DELEGATED DECISION TO DETERMINE PLANNING APPLICATIONS

| Reference No: | 2025/62/90676/W |
| Site Address: | 11, Lea Street, Lindley, Huddersfield, HD3 3LS |
| Description: | Erection of two storey side extension |

Title
Proposed Floor Plans

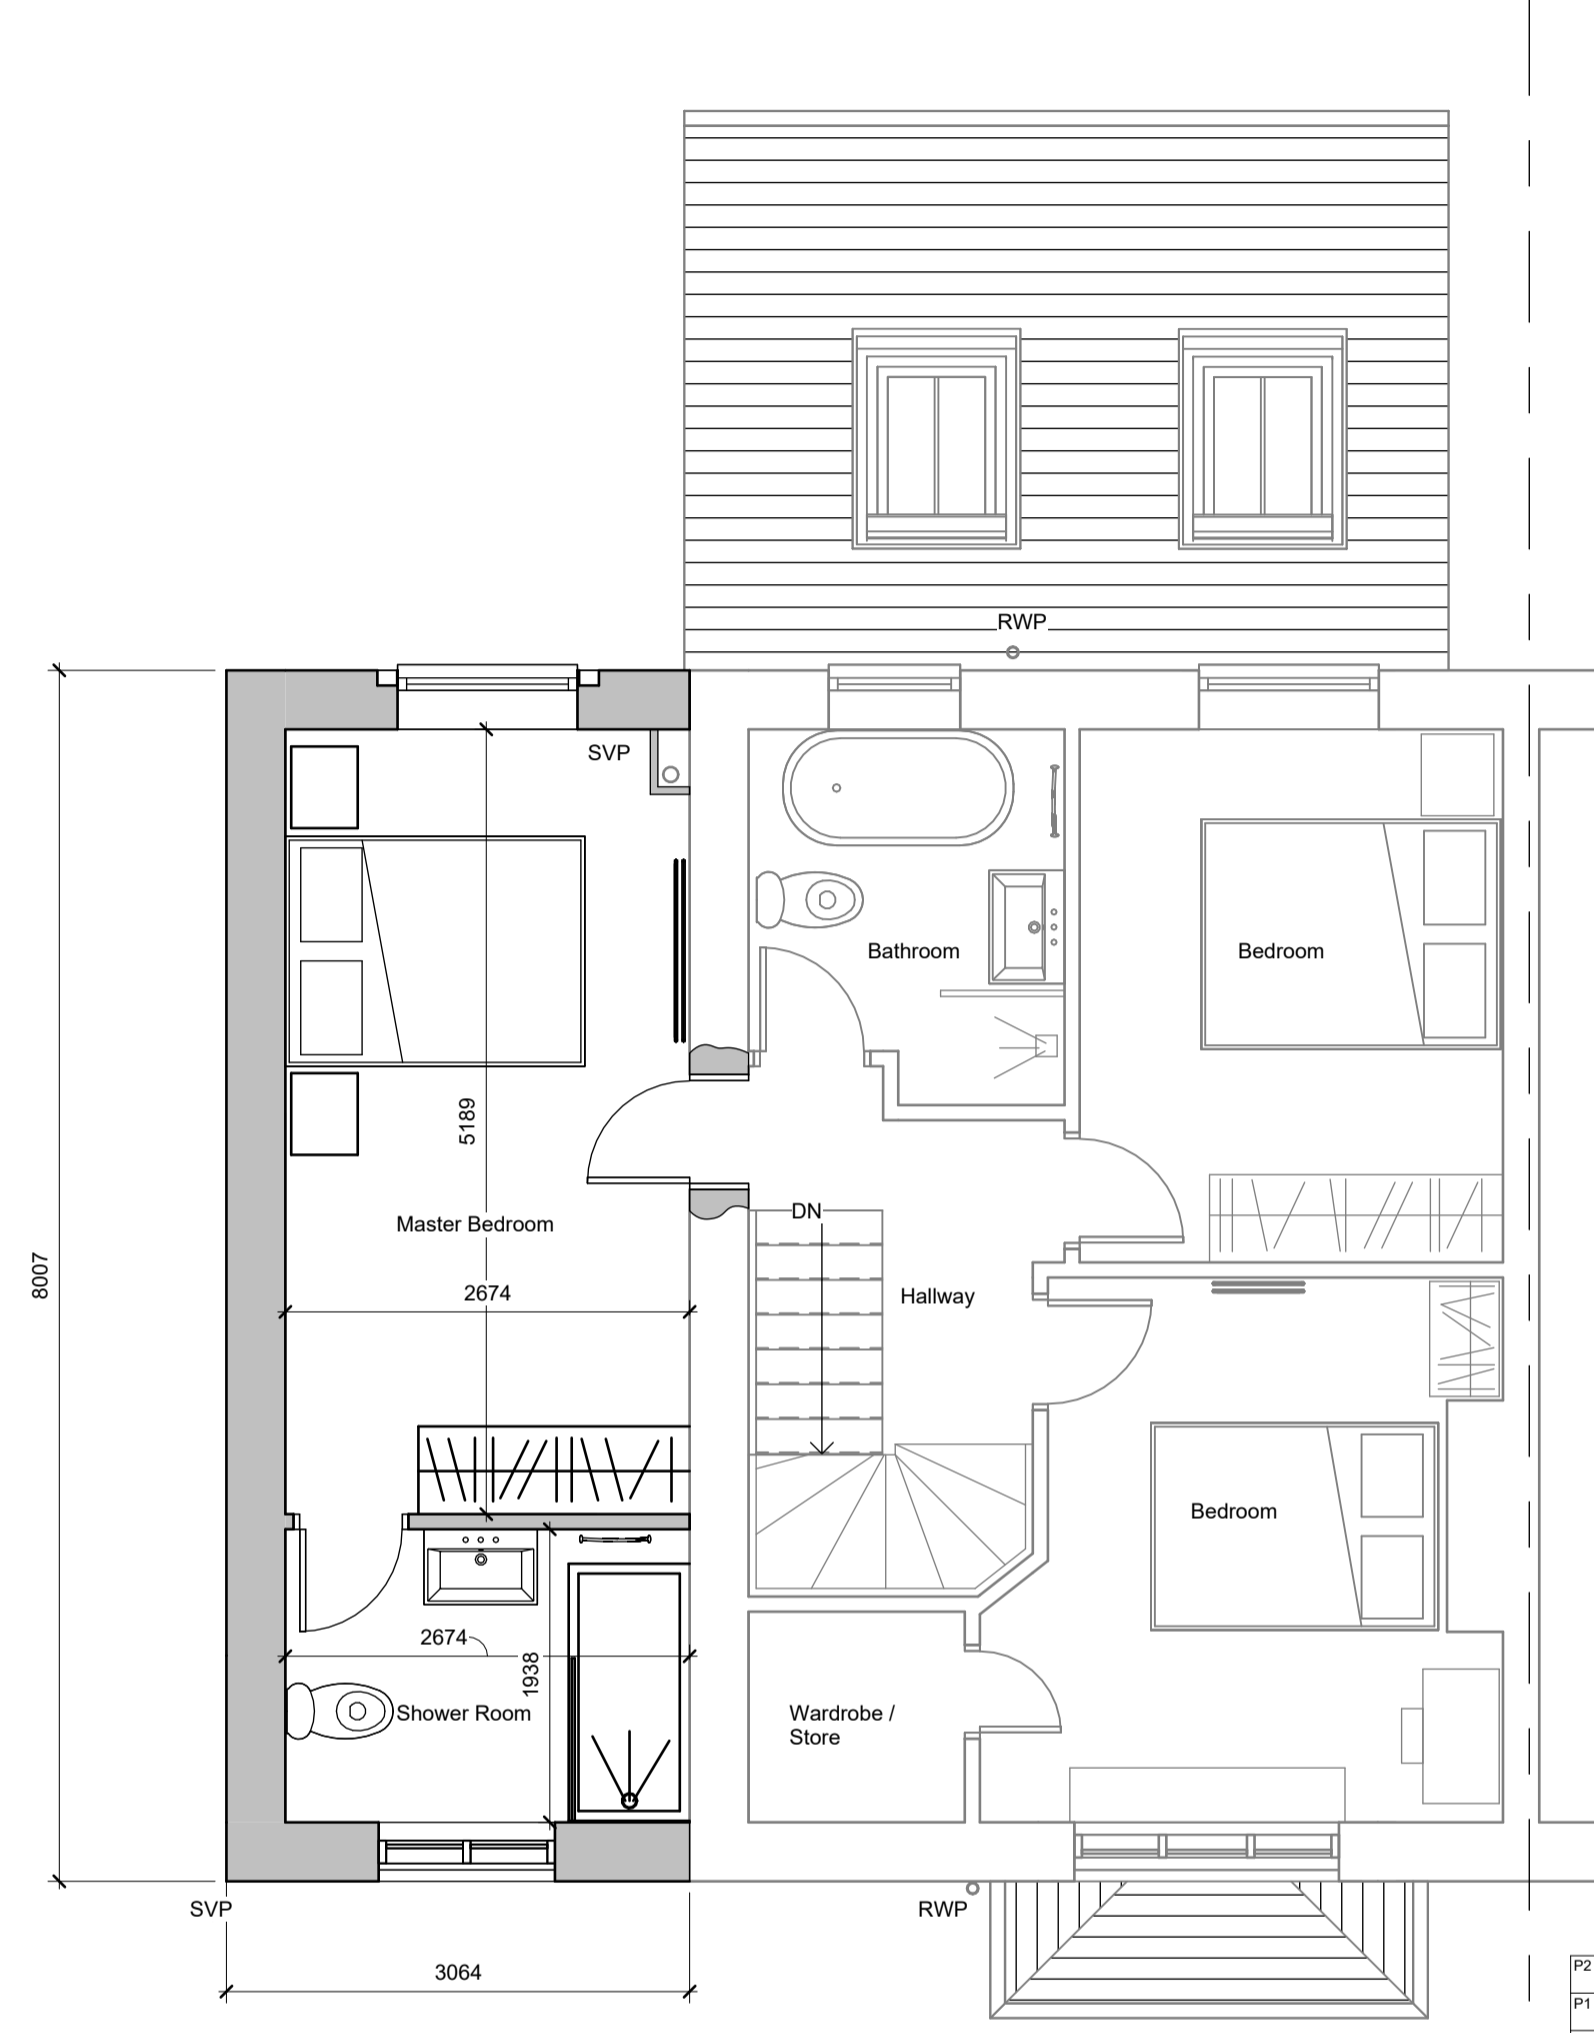
| Not take up all or most of the space to the side of a house | Yes – the extension is set in from the side boundary of the property by 1m. | |
| maintain a 1 metre gap to the side boundary to ensure the building is not too close to a neighbouring property | Yes – a 1m gap is maintained. | |
| be set back at least 500mm from the front wall of the house | | No, the extension will be set in line with the front elevation at the first floor level. At the ground floor level it will be set in by 1.3m however this will be covered by a canopy. Although this does not meet the requirements of the SPD it is considered acceptable as it mirrors the two storey side extension on the adjacent property No.13 and would therefore be in keeping with the street scene. |

| Window proportions | <ul style="list-style-type: none"> • KDP 1 and 2 of the SPD • Policy LP24 Design (a), (c) and (d) of the KLP • Chapter 12 of the NPPF | Openings within the front and rear elevations would be, proportionate in terms of size and scale with the existing. No openings within the side elevation. | ✓ |

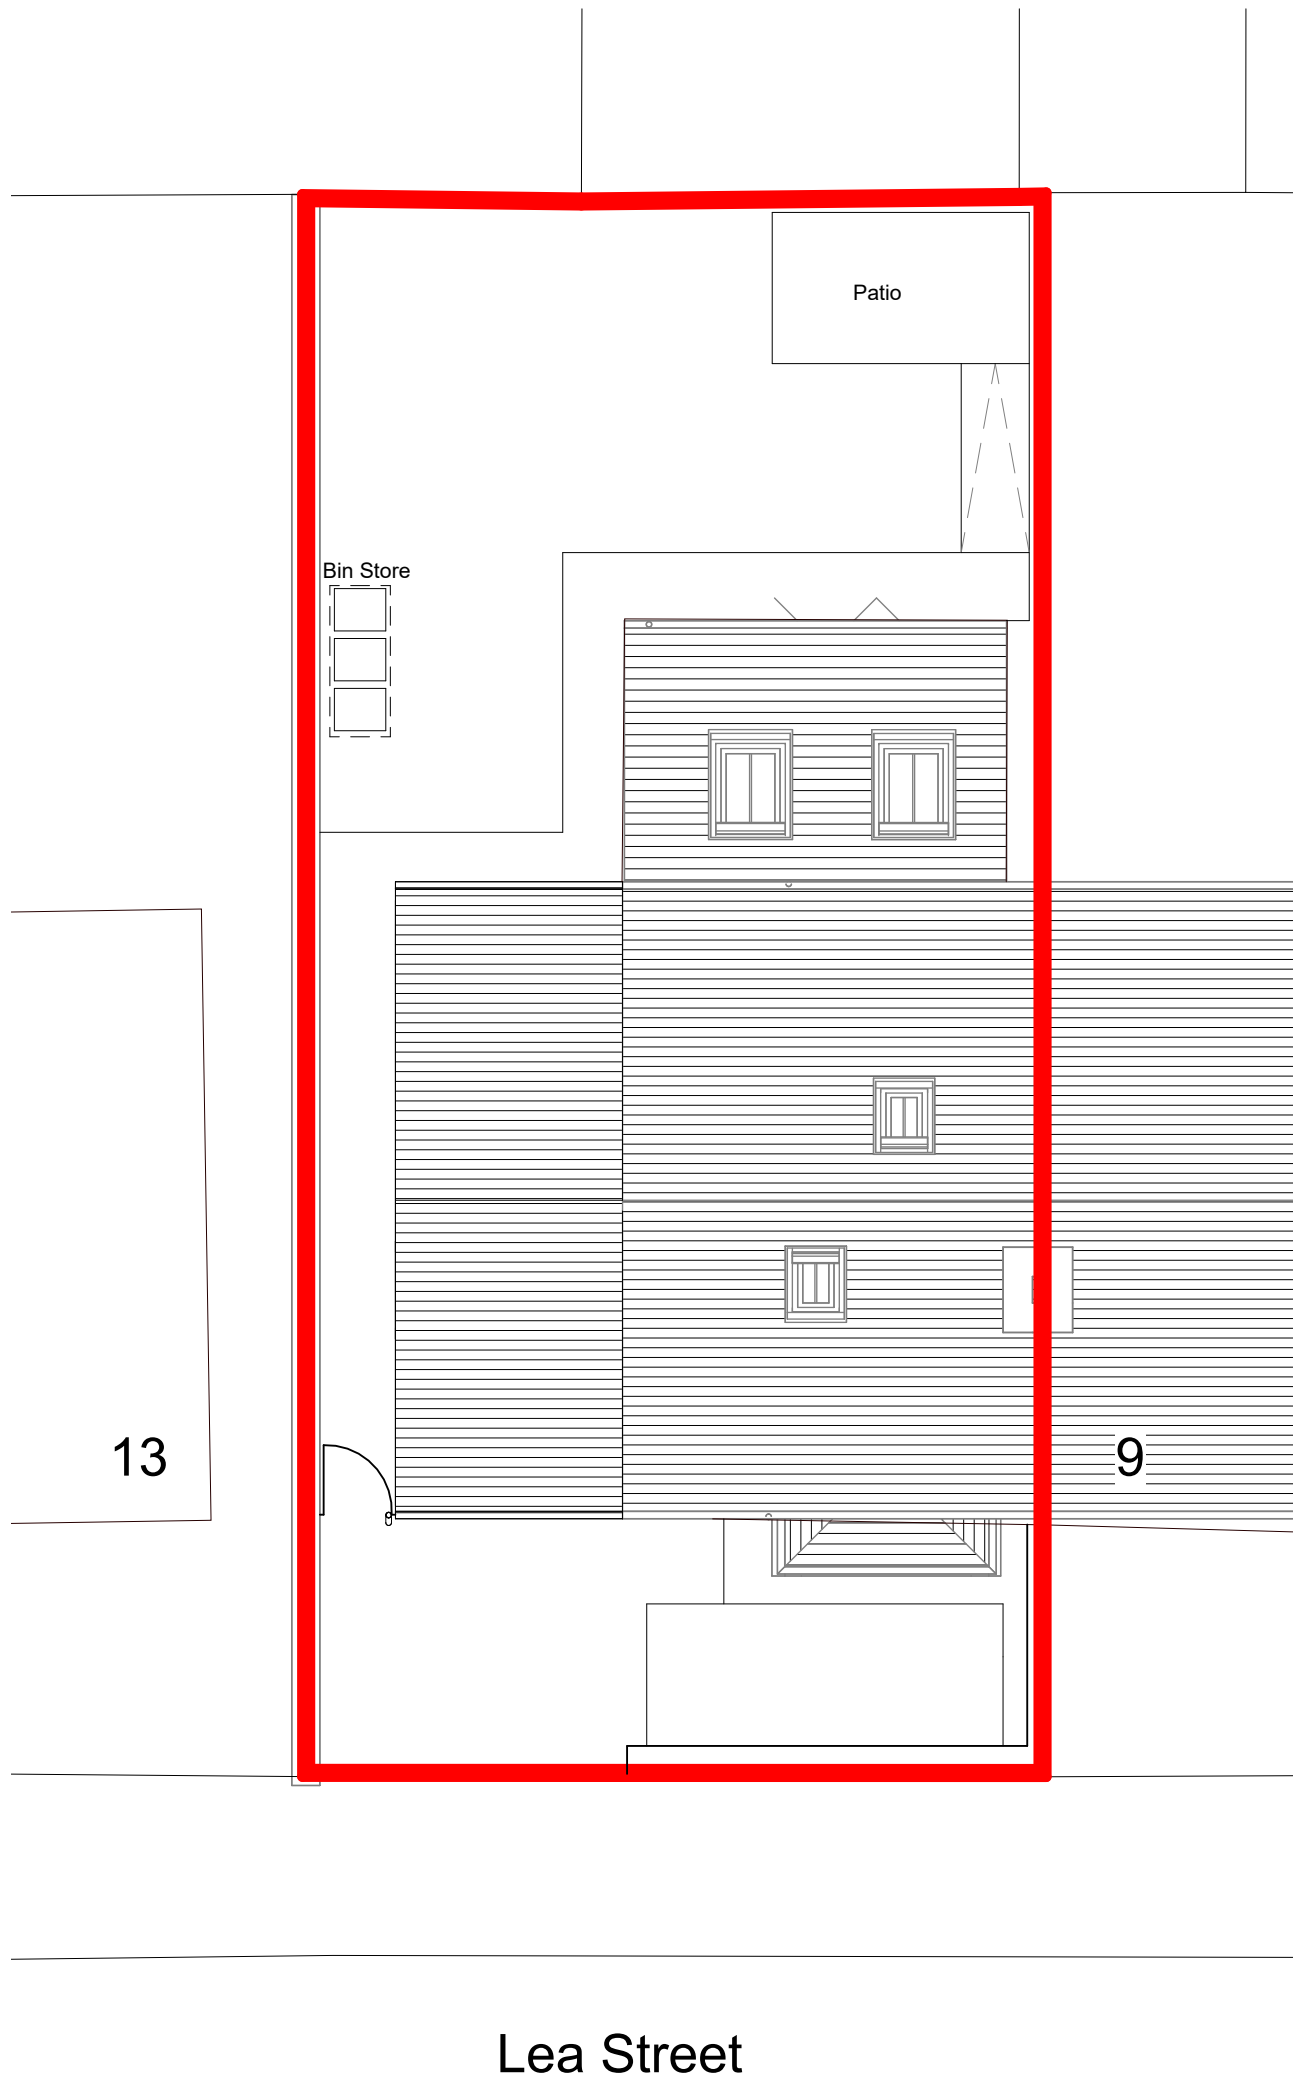
| | Relevant key design principle (KDP) of the SPD, Policy in the Kirklees Local Plan and the NPPF | Further comments | ✓ / X / N/A |
|--------------------------|---|--|----------------------------|
| Parking provision | <ul style="list-style-type: none"> • KDP 15 of the SPD • Policy LP22 Parking (f) of the KLP • Chapter 12 of the NPPF | <p>The property would see one additional bedroom and it is considered that although the extension would reduce the parking area at the property a large part of the driveway would be retained and it is considered that there is no significant strain on parking within the street.</p> <p>Currently there is one usable off street parking space to the front of the host property and this would remain. In this case it is considered the benefit of soft landscaping in the street outweighs the benefit of creating off street parking upon this area of land and it is not considered necessary to require creation of further</p> | ✓ |

| | | off street parking in this case given the existing situation at site with the existing garage not meeting size requirements to serve as a functional off street space. | |
| Provision for waste storage | <ul style="list-style-type: none"> • KDP 16 of the SPD • Policy LP24 Design (d) (iv) • Chapter 12 of the NPPF | None shown on plan however sufficient space within the site boundary to accommodate bin storage | ✓ |
